From: Speakman, Glenn - Oxfordshire County Council
<Glenn.Speakman@Oxfordshire.gov.uk>
Sent: 17 April 2023 11:07
To: Gemma Magnuson; DC Support
Cc: Transport CDC Minor; Cllr Nigel Simpson
Subject: 23/00750/TEL56 Street Record, Station Road, Kirtlington

Planning application:	23/00750/TEL56
Location:	Street Record, Station Road, Kirtlington
Description:	Proposed telecommunications installation: Proposed 15.0m Phase 9 slimline Monopole and associated ancillary works
Case Officer:	Gemma Magnuson

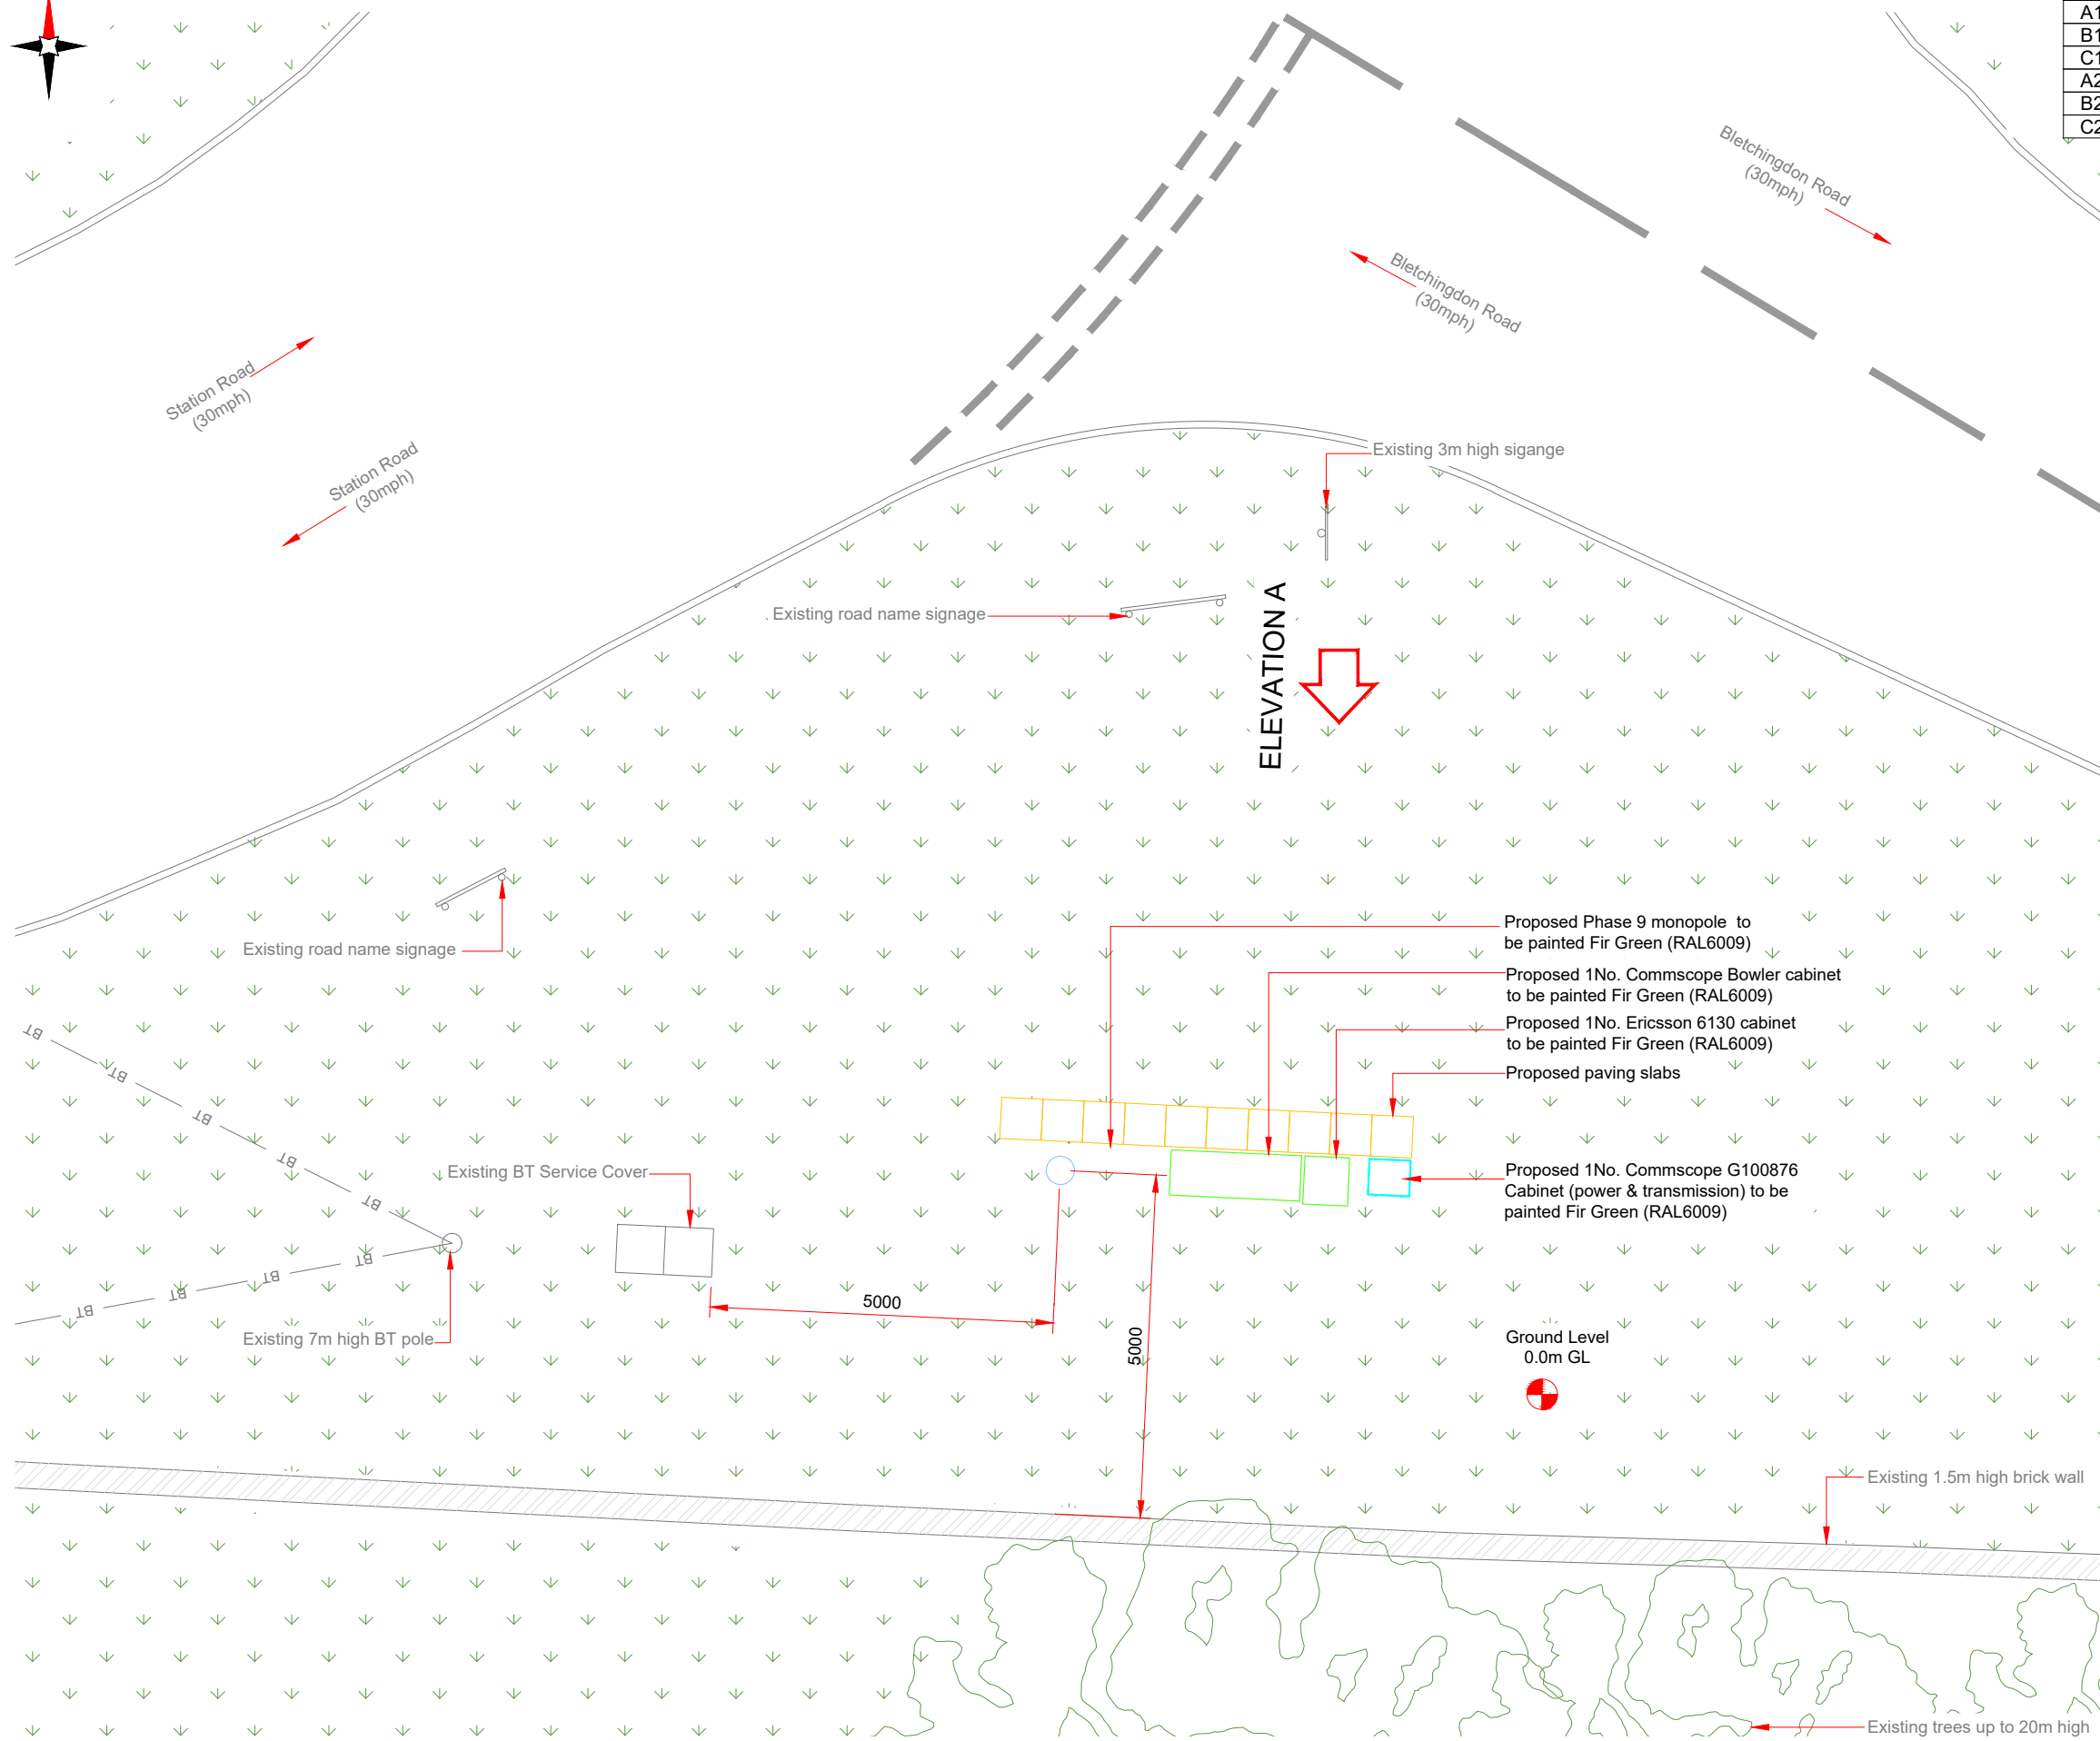
The proposed mast and cabinets will not adversely affect visibility for drivers.
